CITY OF ALBUQUERQUE
PLANNING DEPARTMENT
Hydrology Section
Predesign Meeting Conference Notes
DATE: 12/15/14

ADDRESS: 7201 Central NW

DRAINAGE FILE: K10D015

Provide a northern access drive from Legacy Church to Unser Blvd. Some of the driveway would be in two northern lots where existing ponds and drainage easements are now.

LEGACY CHURCH WEST ACCESS ROADWAY DRAINAGE PLAN

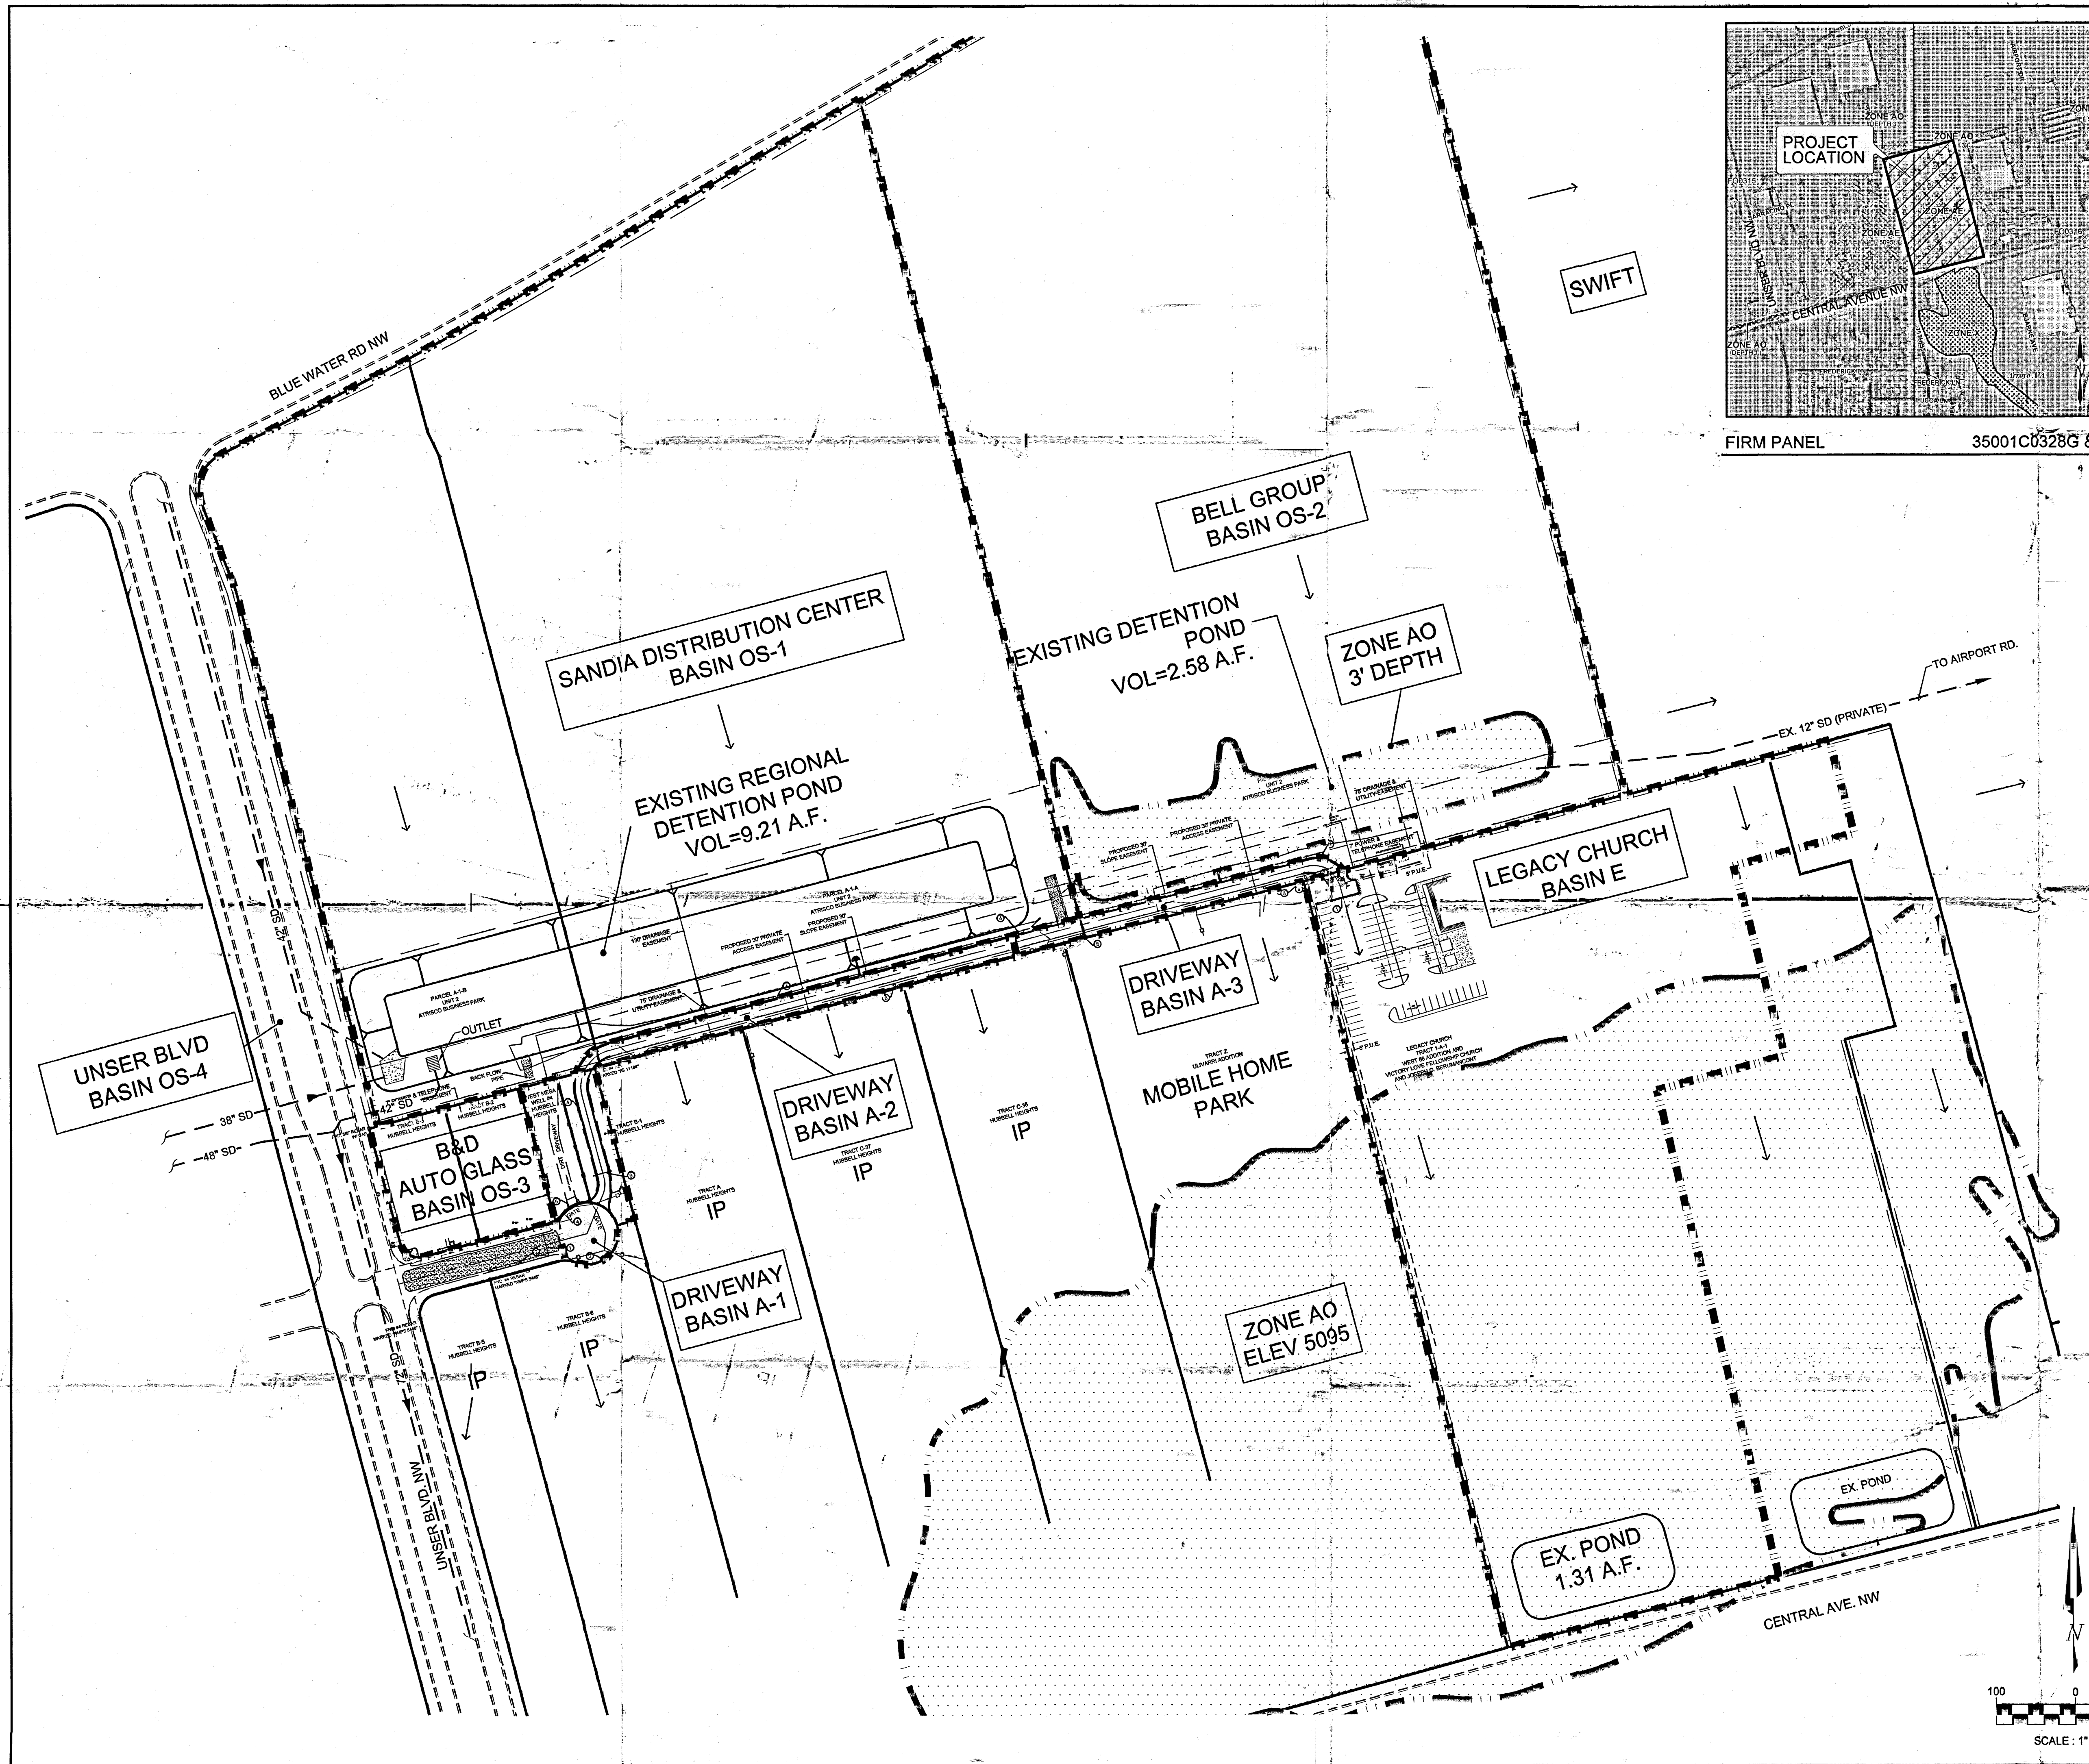
2. Provide topo of the existing pond on the Sandia property and on the Bell Group property. Base existing volume off of this topo. Base proposed flows on 100 year, 24 hour storms. The detention ponds are being partially filled by the design for the road. Modify detention ponds so that enough volume is provided for the change due to the road and for the additional flows. We will accept a design flow of 9.5 ac-ft for the Sandia detention pond. Include excerpts from the Atrisco Business park MDP discussing the Sandia pond.

3. Submit the modification of the Public Sandia pond for Work Order.

TITLE:
LEGACY CHURCH
WEST ACCESS ROADWAY SITE PLAN

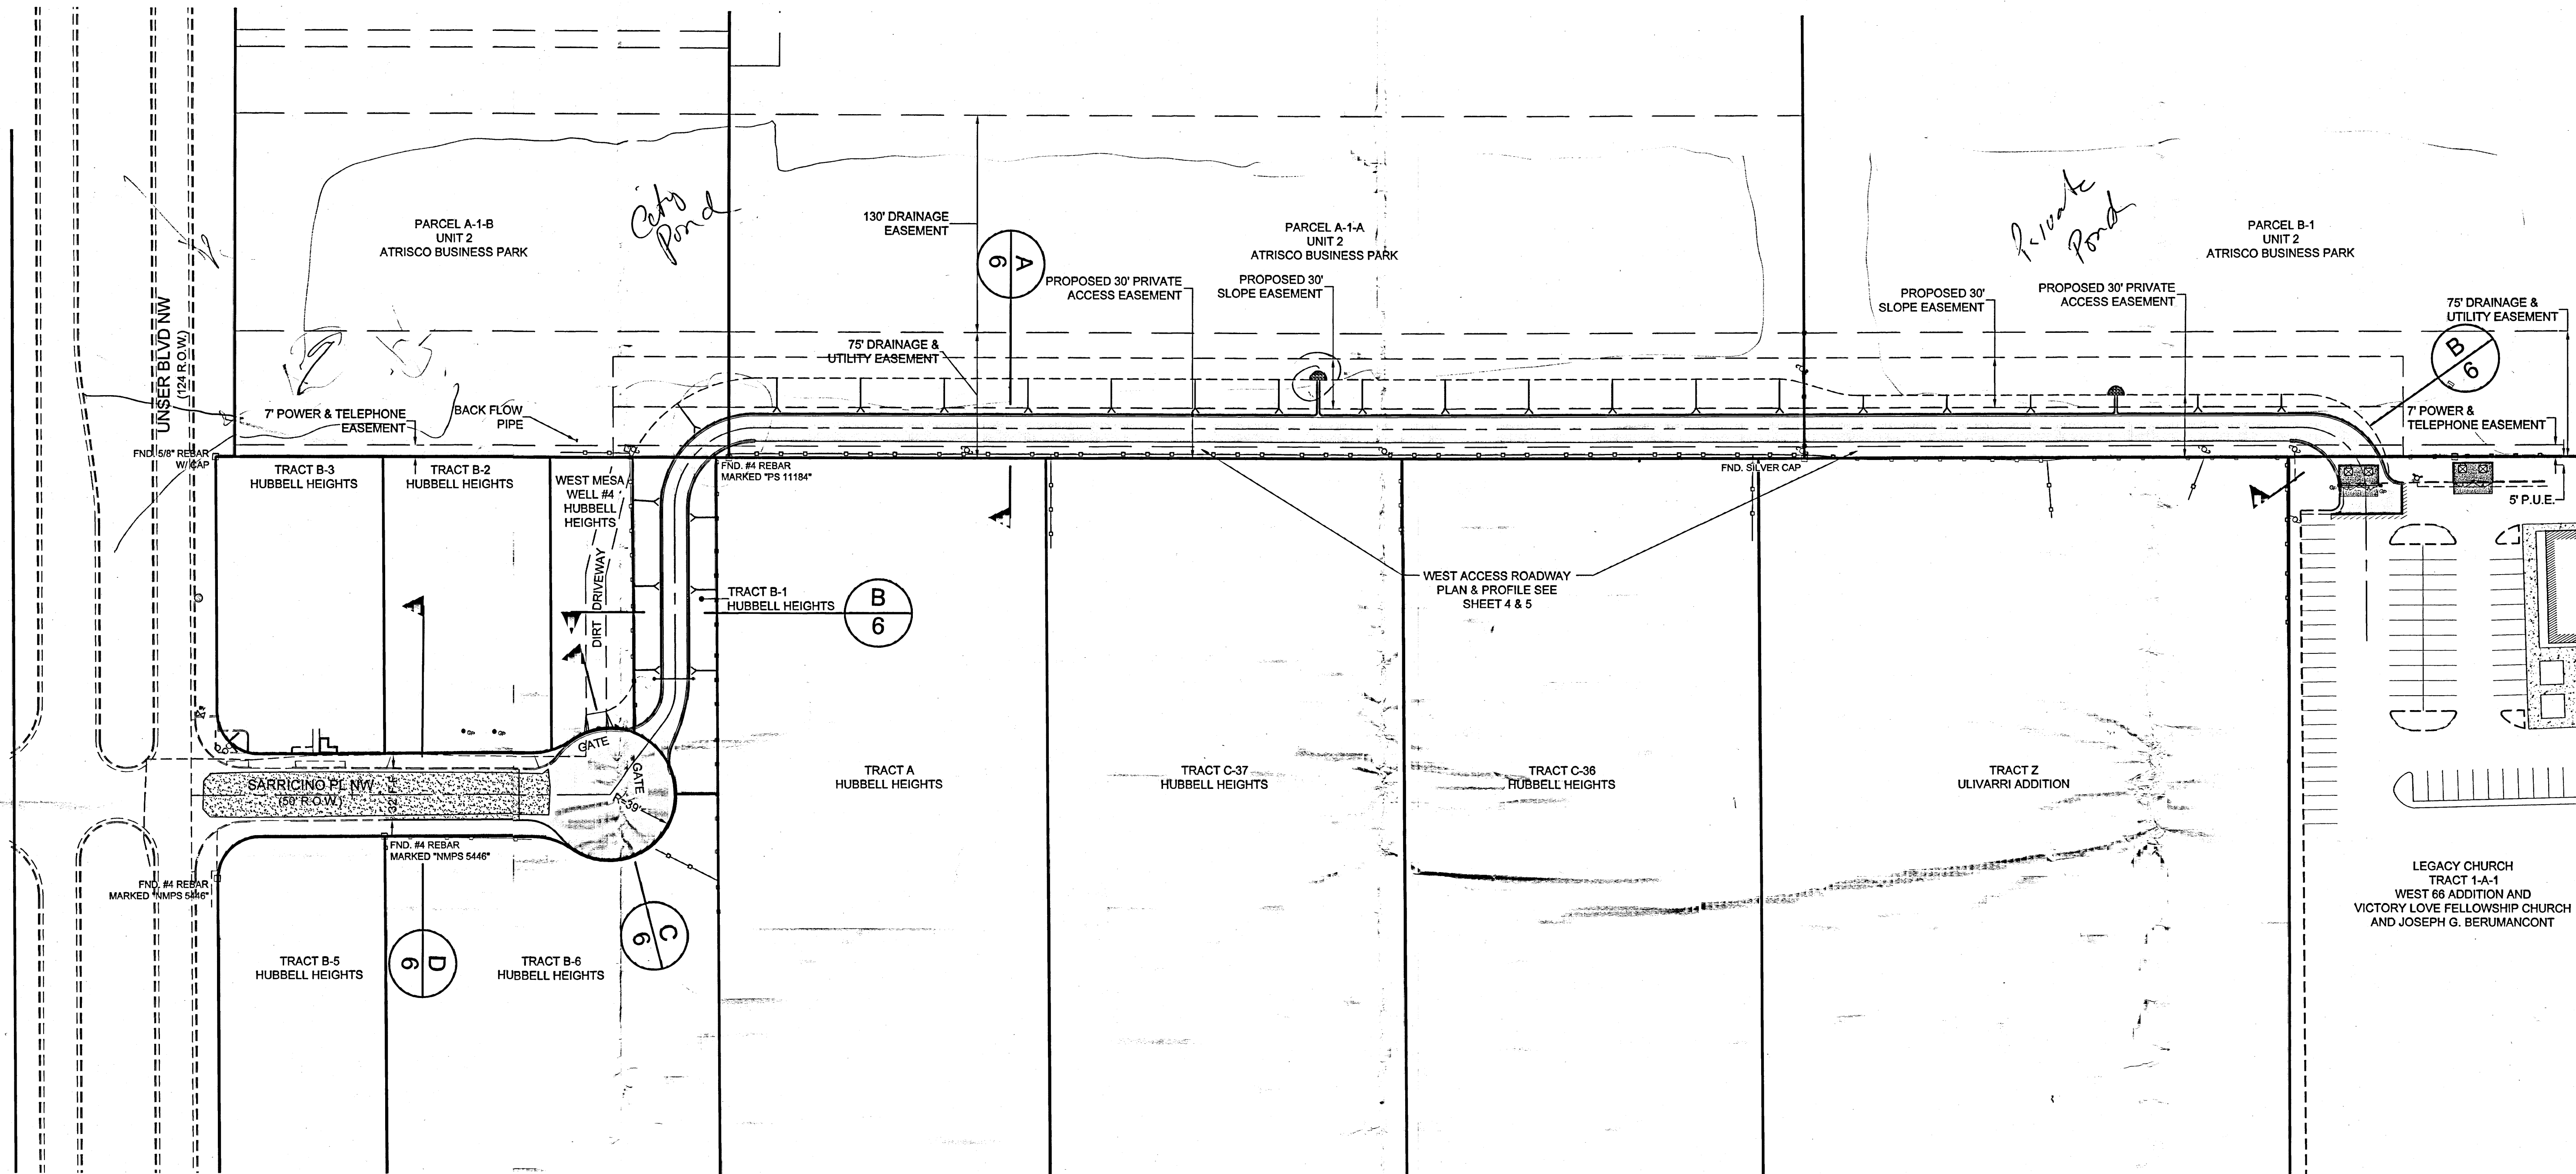
1. Vacate the public and private drainage easements on the Sandia Distribution Center and Bell Group properties. Provide new easements for the public and private drainage ponds and for the private roadway. The drainage easements and private roadway easements should not overlap. This will also necessitate an Administrative Amendment due to the IP and SU-1 zoning.
